LOT 1 OF THE ROCK COMMERCE CENTER SUBDIVISION FILING NO. 1

PUBLIC IMPROVEMENT PLAN CONSTRUCTION DOCUMENTS

LOT 1 OF THE ROCK COMMERCE CENTER SUBDIVISION FIL. NO. 1
PUBLIC IMPROVEMENTS PLAN
CONSTRUCTION DOCUMENTS
COVER SHEET

THE ROCK COMMERCE CENTER
PUBLIC IMPROVEMENTS PLAN
CONSTRUCTION DODUMENTS
DEMOLITION PLAN

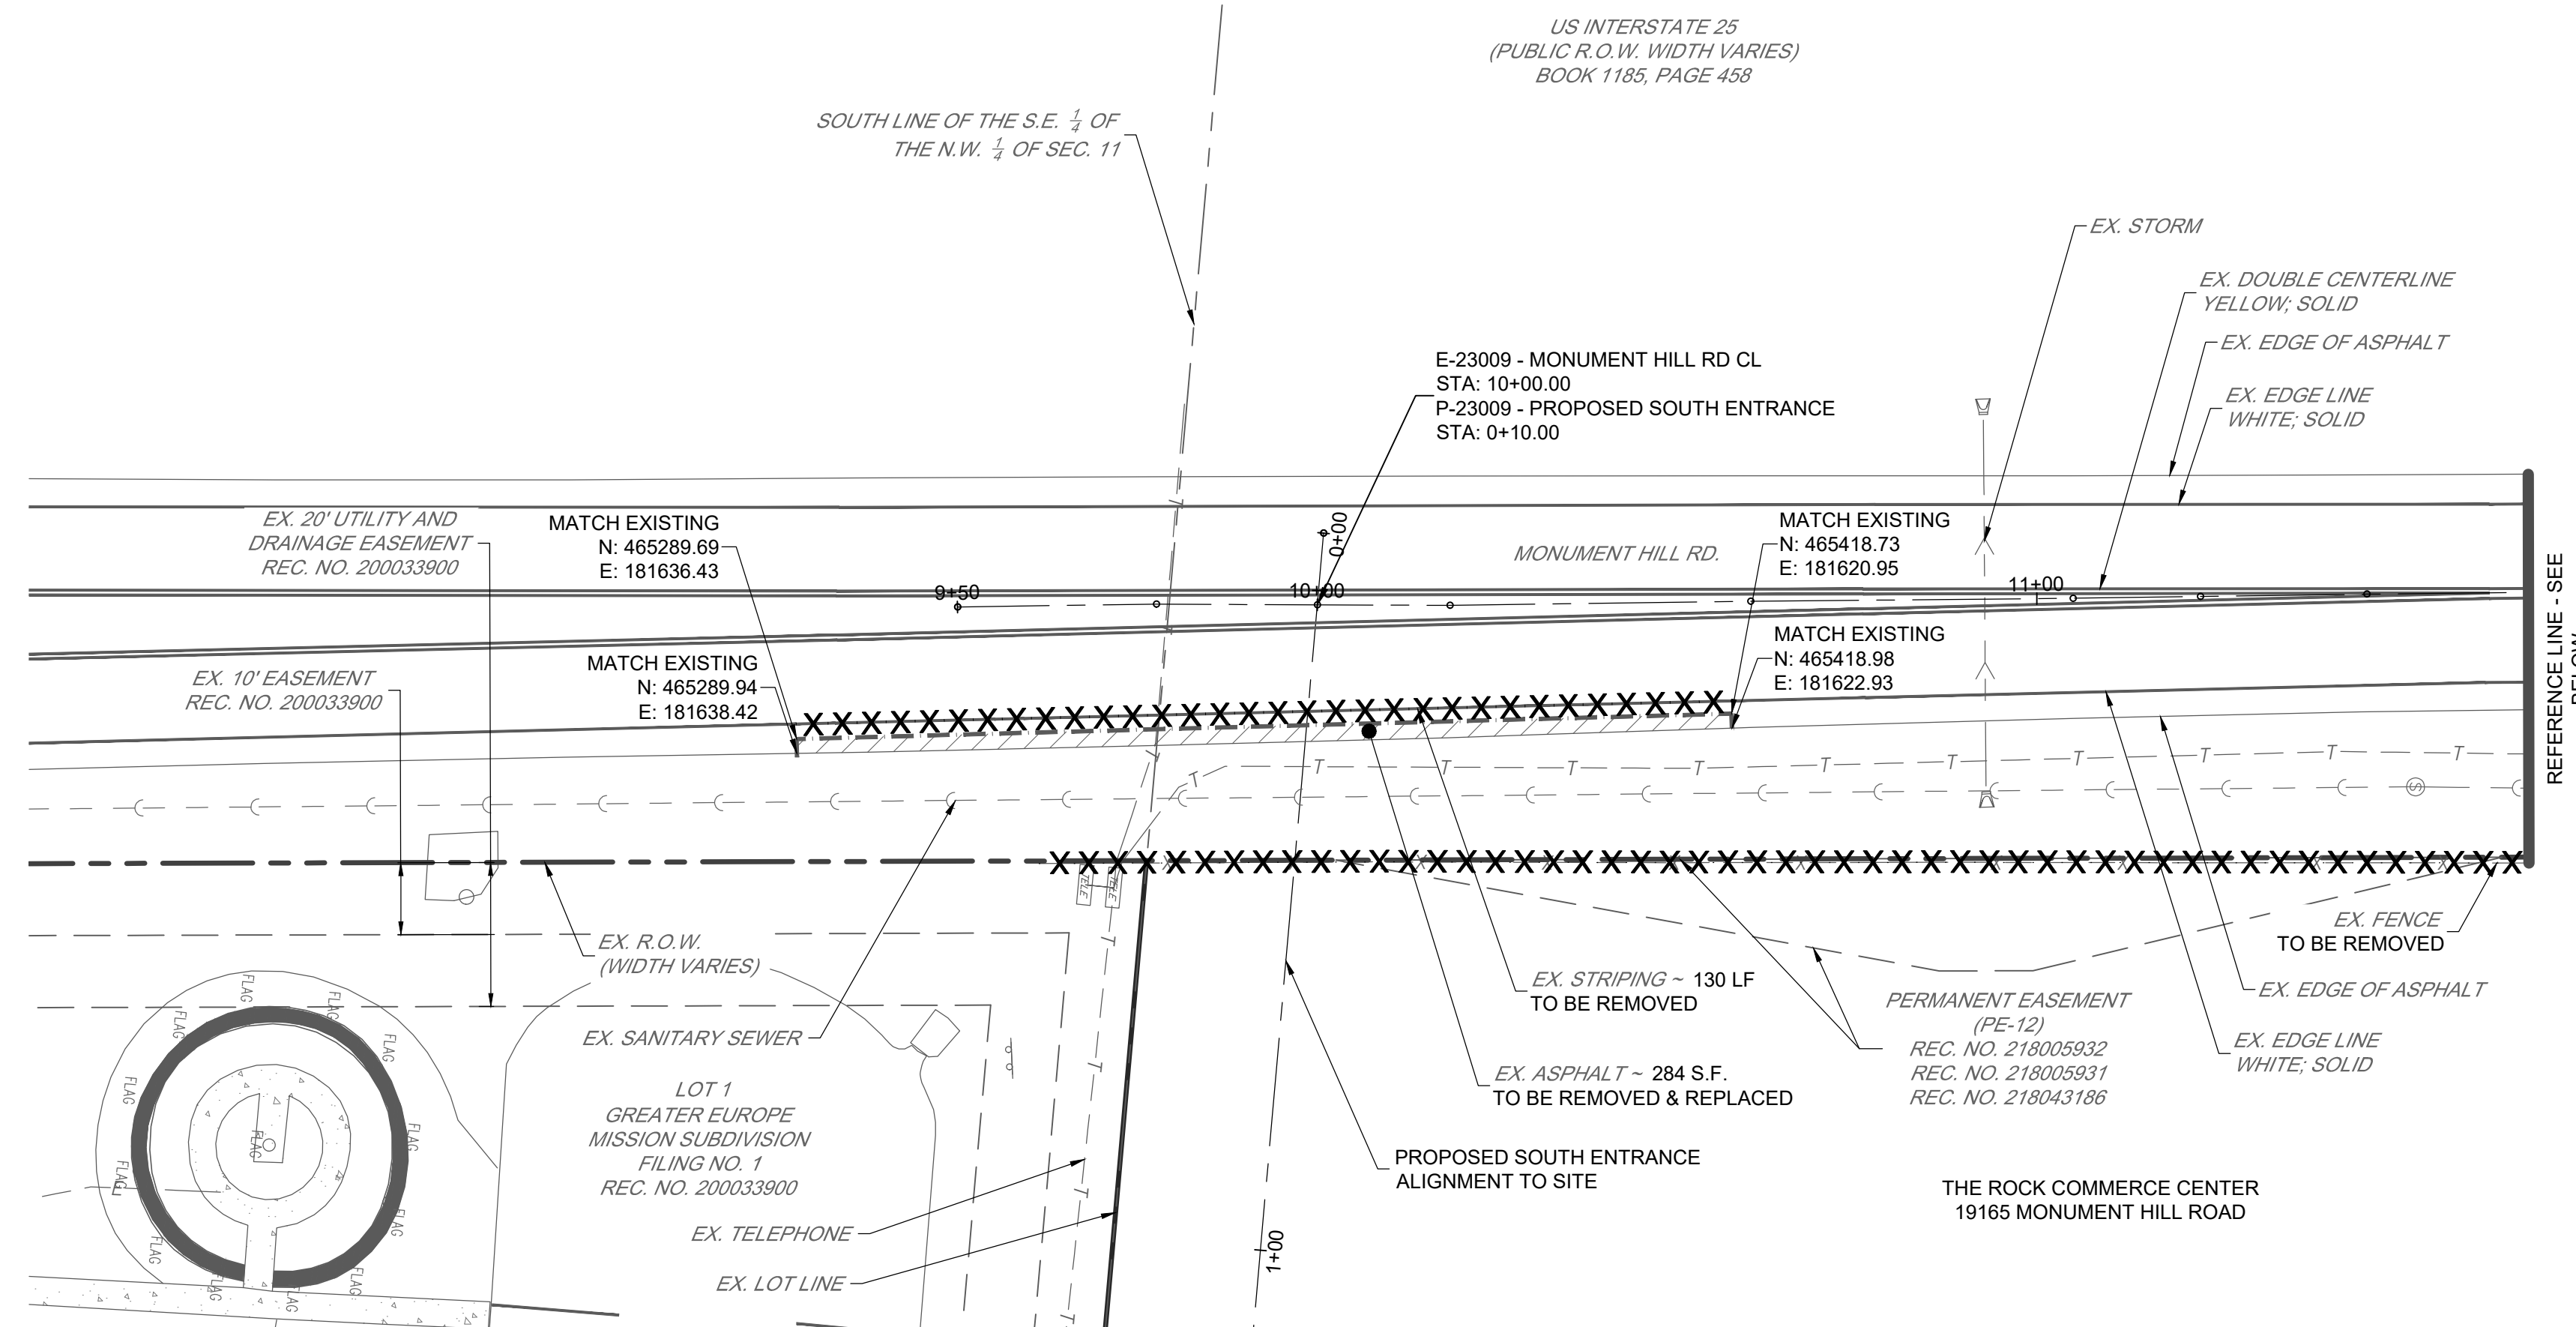
Include symbol in legend.

THE ROCK COMMERCE CENTER
PUBLIC IMPROVEMENTS PLAN
CONSTRUCTION DOCUMENTS
HORIZONTAL CONTROL PLAN

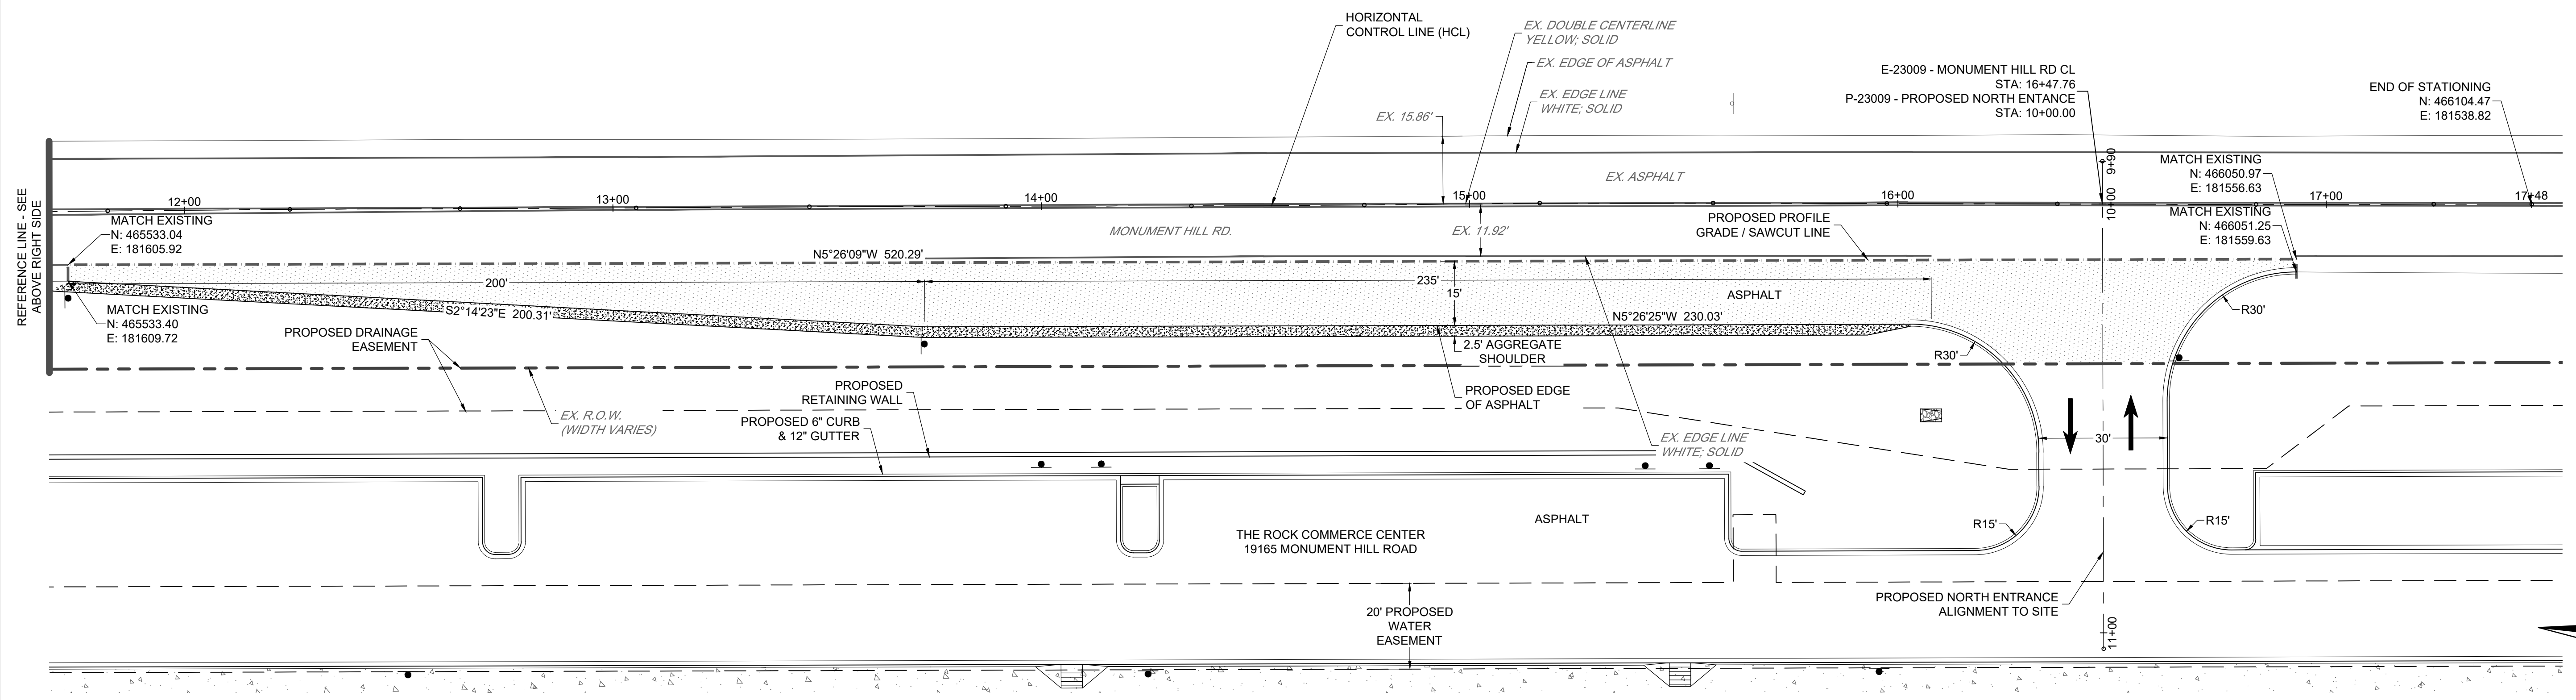
Please revise curb return radius. The minimum radius is 30 feet per ECM Chapter 2.

THE ROCK COMMERCE CENTER
PUBLIC IMPROVEMENTS PLAN
CONSTRUCTION DOCUMENTS
PLAN AND PROFILE

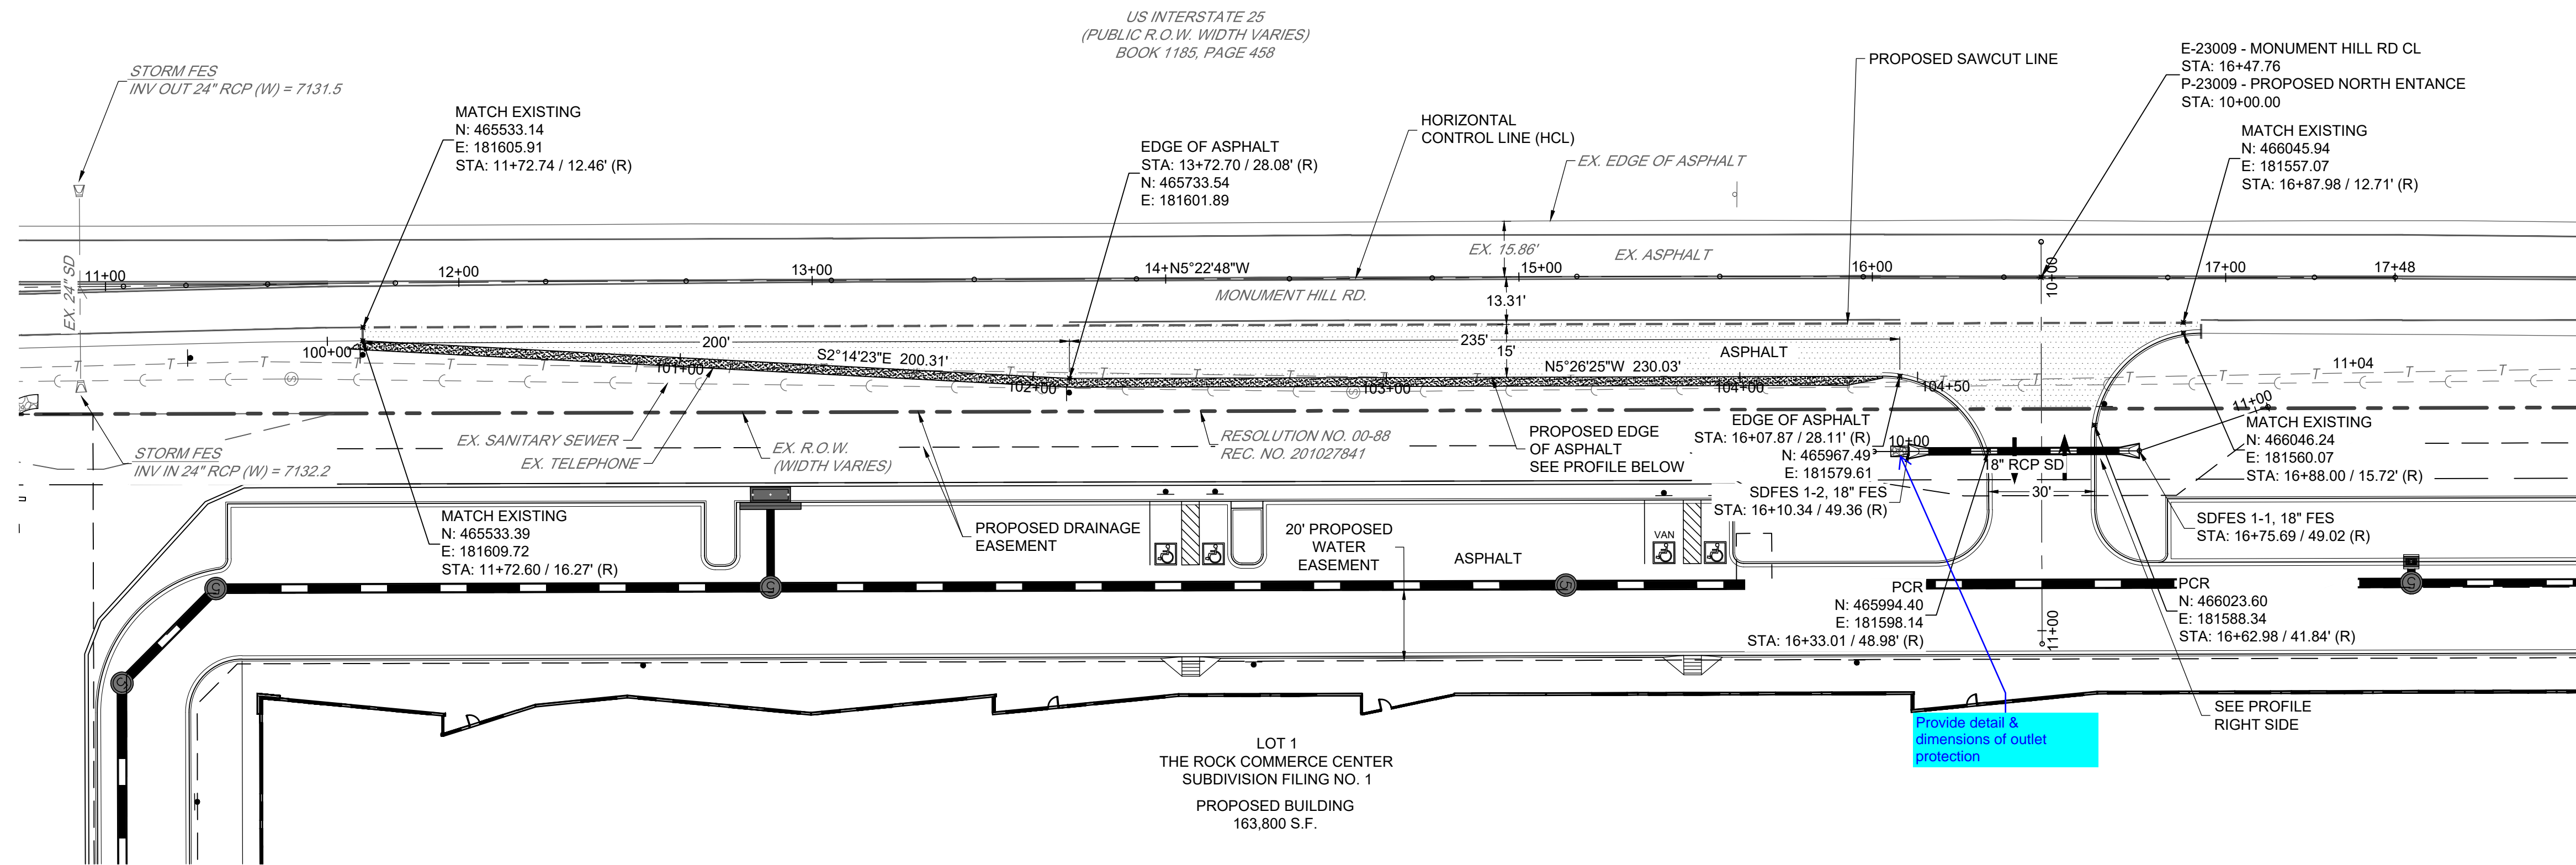
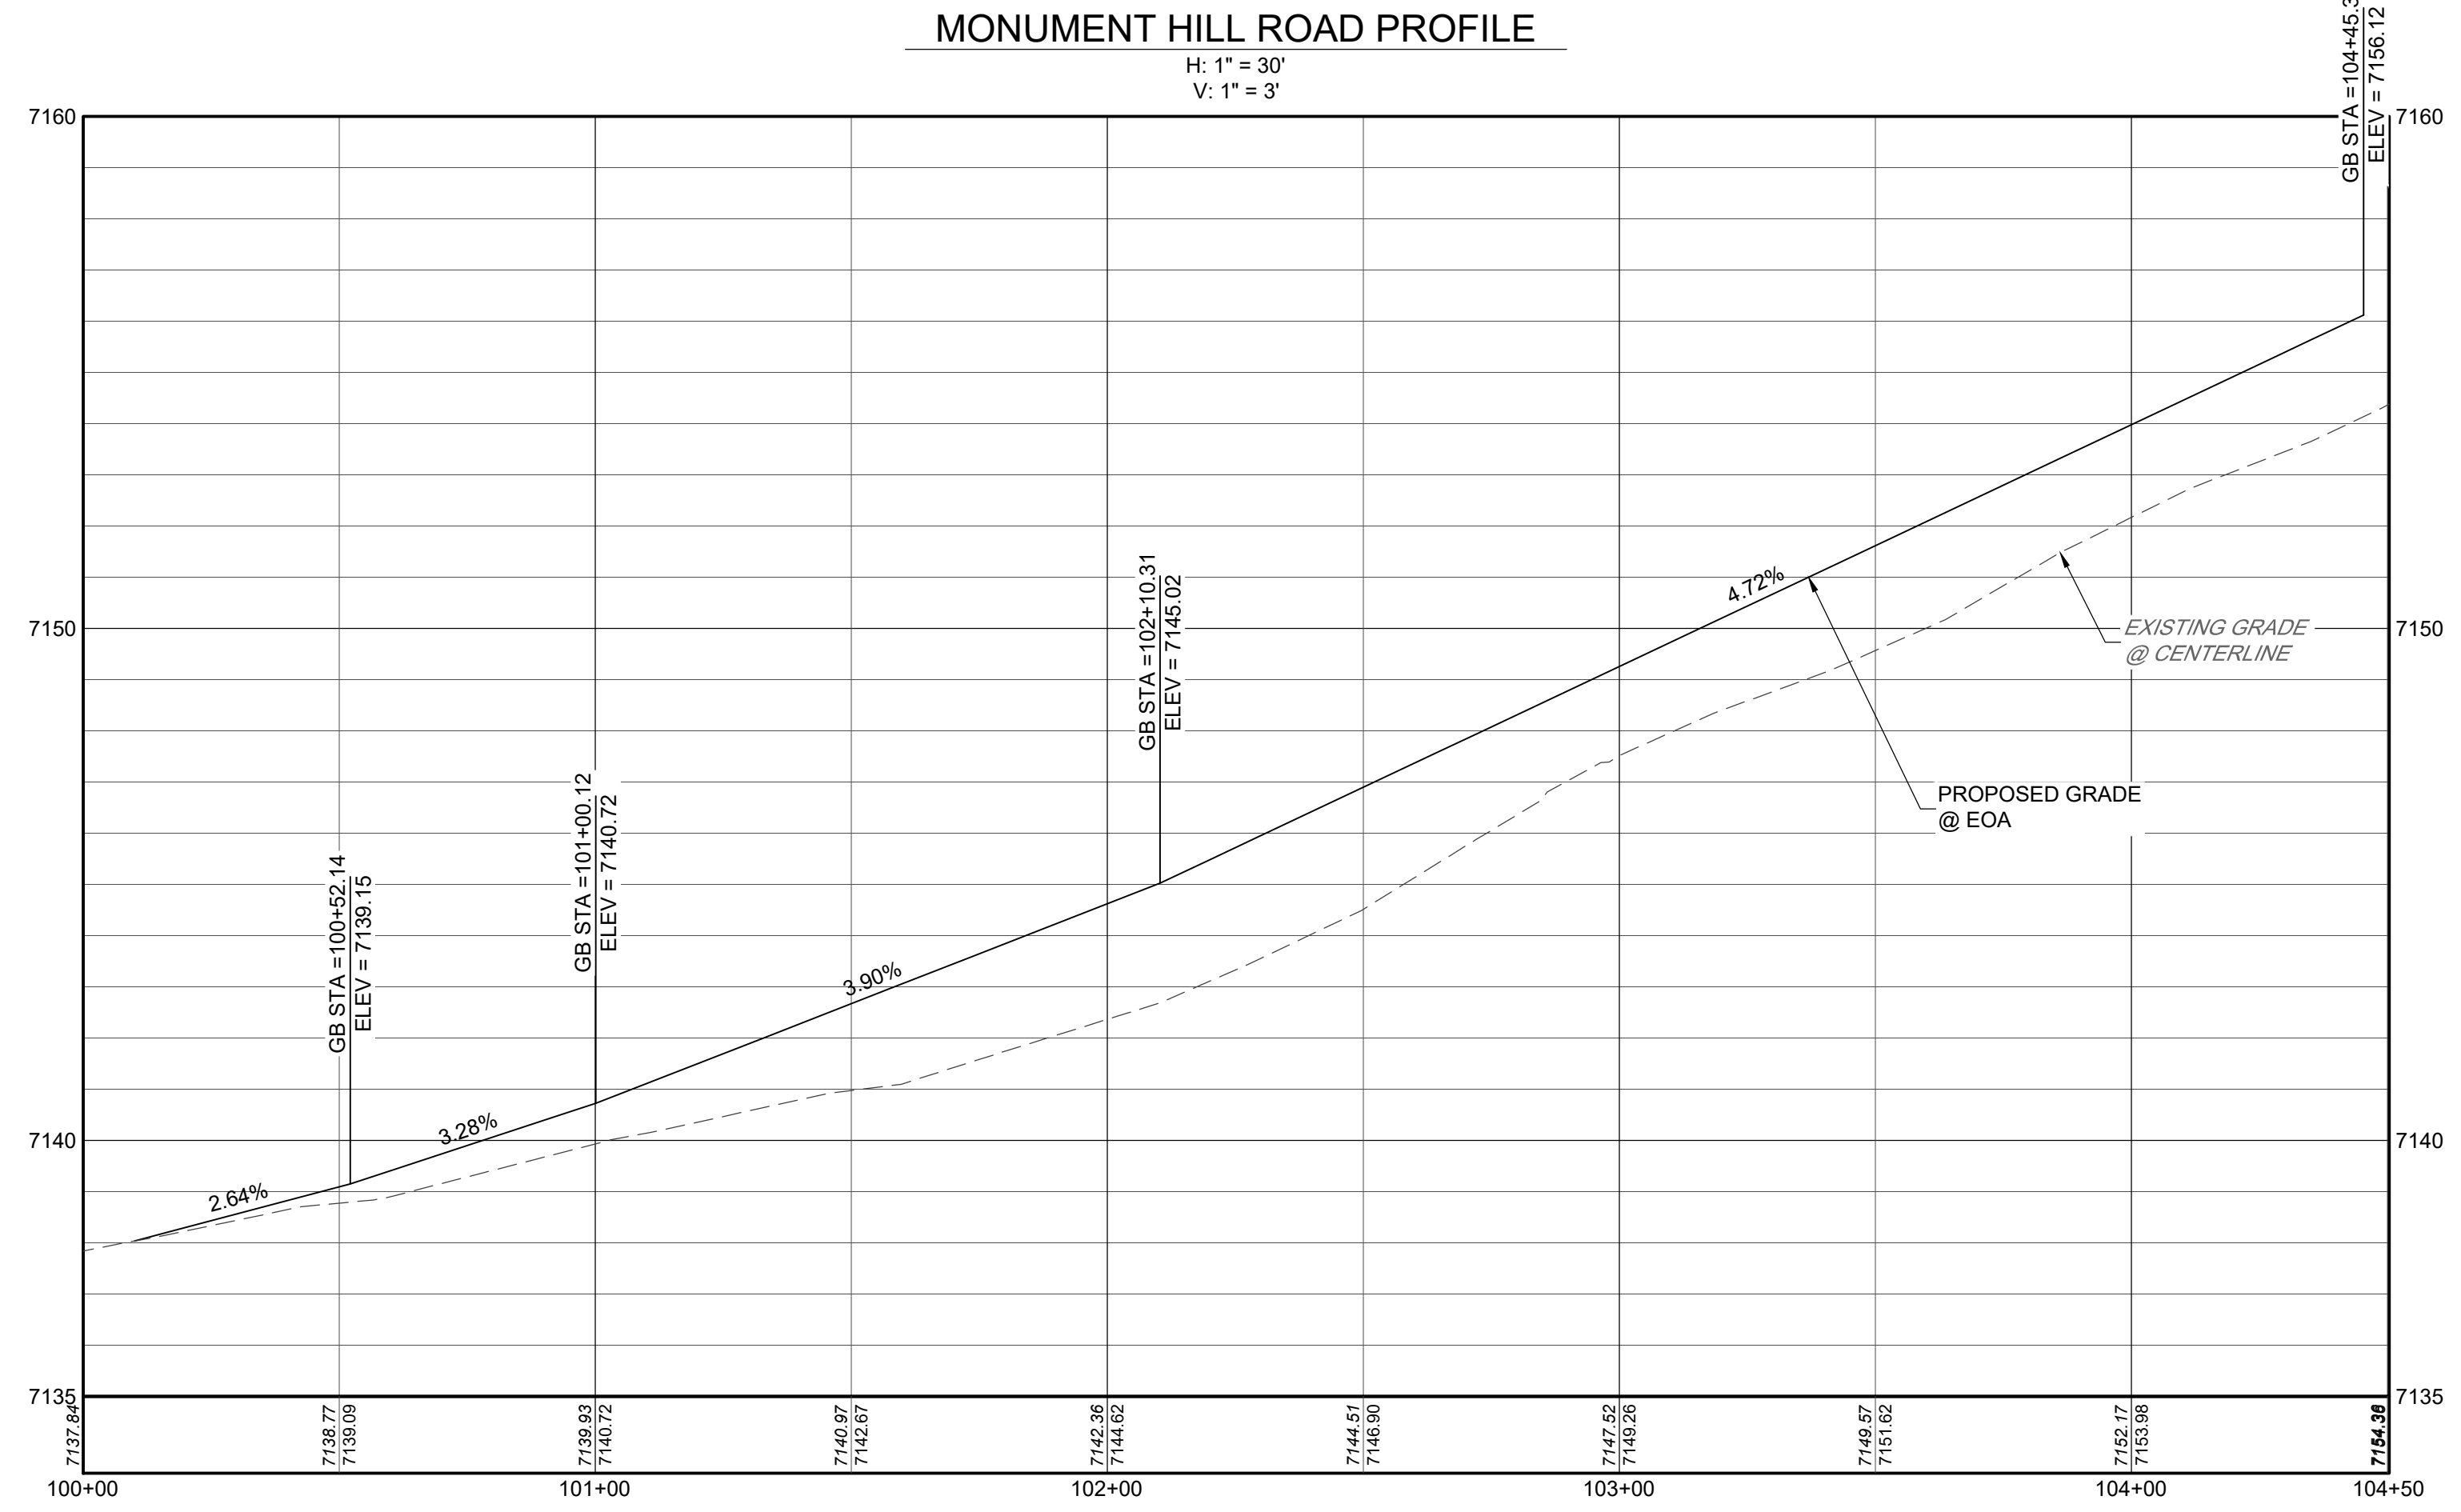
Please include a disclaimer. This may be used for bidding purposes only. However, the actual pavement design is subject to change pending Pavement Design Report submittal.

Show all utility crossings on the profile view.
